# CITY OF ALBUQUERQUE

**RE: Burger King – 5508 4<sup>th</sup> Street NW**  
**Grading and Drainage Plan**  
**Stamp Date: 11/09/17**  
**Hydrology File: F14D055**

**RE: Burger King – 5508 4<sup>th</sup> Street NW**  
**Grading and Drainage Plan**  
**Stamp Date: 10/30/17**  
**Hydrology File: F14D055**

ENGINEER'S SEAL  10-30-17 Richard Dourte P.E. #10854	Title BURGER KING 4TH ST. AND MONTANO RD 5508 4th Street NW GRADING AND DRAINAGE PLAN  <i>RHD Engineering, LLC</i> 4305 Purple Sage Ave. NW ALBUQUERQUE, NM 87120 (505) 288-1621	DRAWN BY DATE OCT. 2017  SHEET # 1 of 2  JOB #
---	--	--

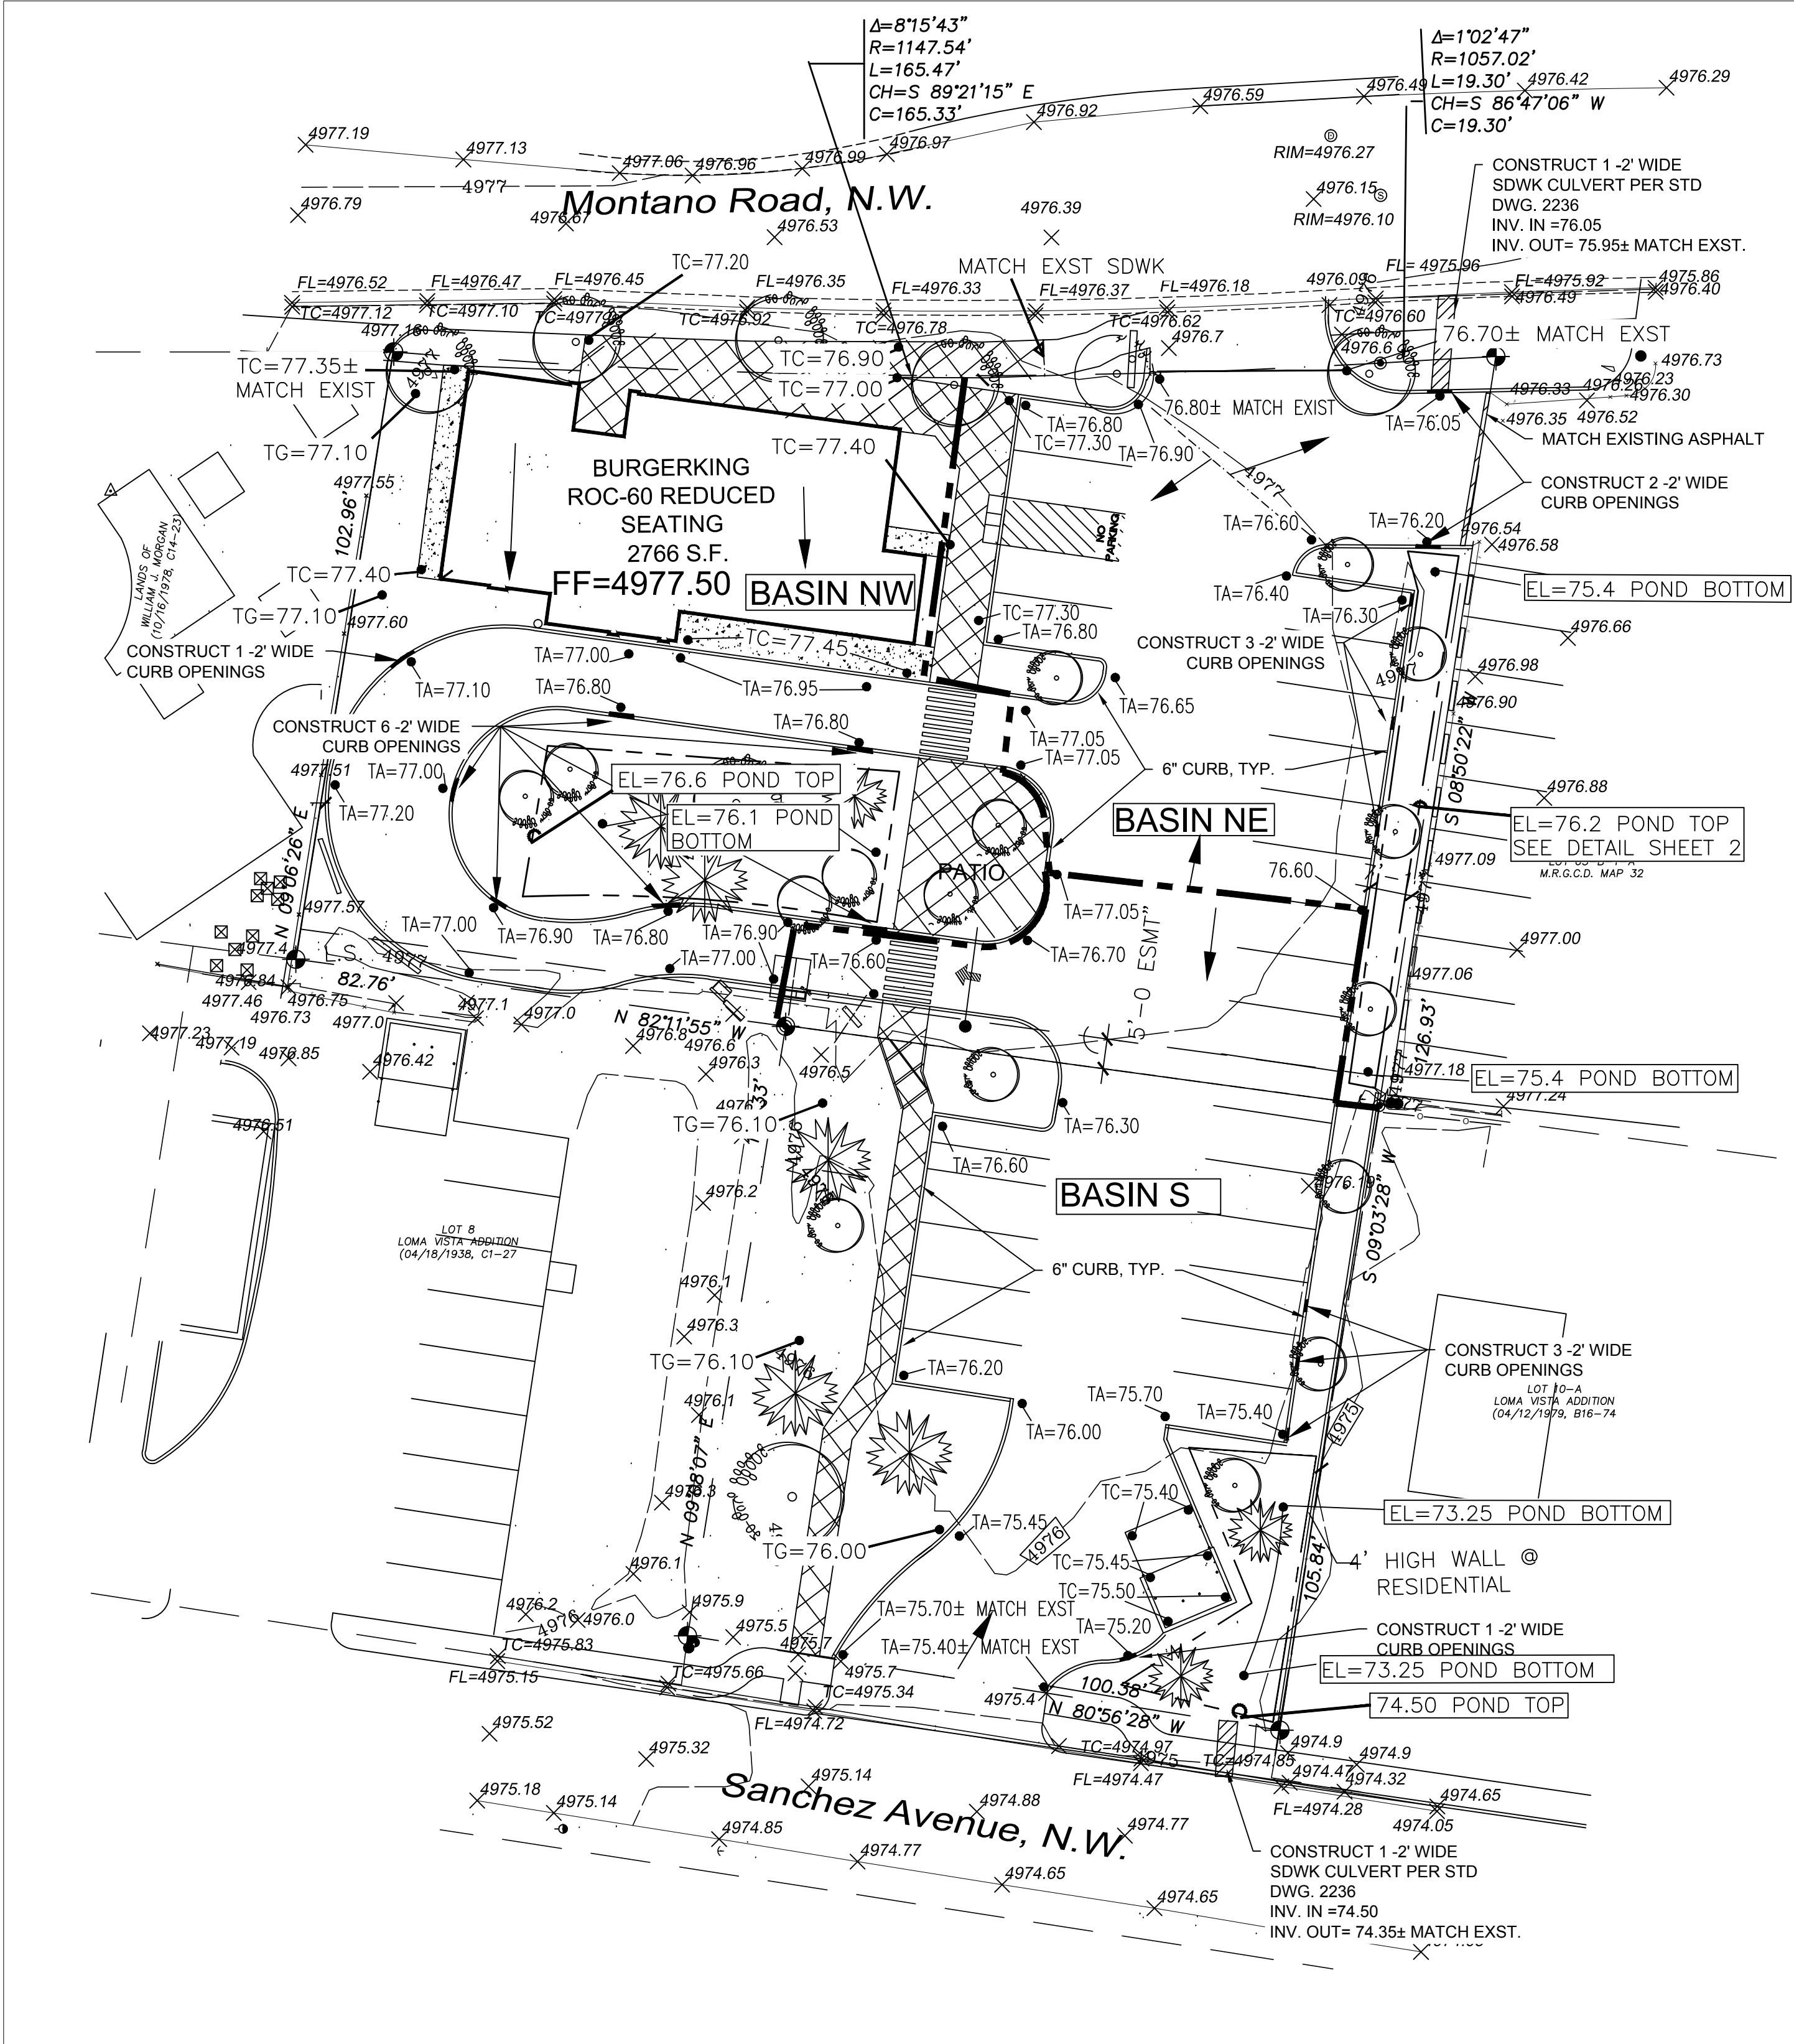
1. Please darken the property line or make the proposed basin boundary go around the property line. It is hard to tell what is within the site.

2. Please provide the weir calculations for the curb cuts and sidewalk culverts.

3. The sidewalk culverts will need a SO-19 Permit. Please mark the DTIS in your re-submittal and add the standard SO-19 notes (See below).

1. The property lines have been darkened and the basin boundaries have been modified to provide better clarity with respect to drainage basins.
2. Weir calculations have been included on the drainage plan, since the flow to the southern sidewalk culvert was at capacity another sidewalk culvert was added. This is shown on the drainage plan.
3. The sidewalk culverts will require an SO-19 permit so the notes that you requested were added to the drainage plan. The call outs for the sidewalk culverts also include a note to this effect. The DTIS form will specify the need for the SO-19.
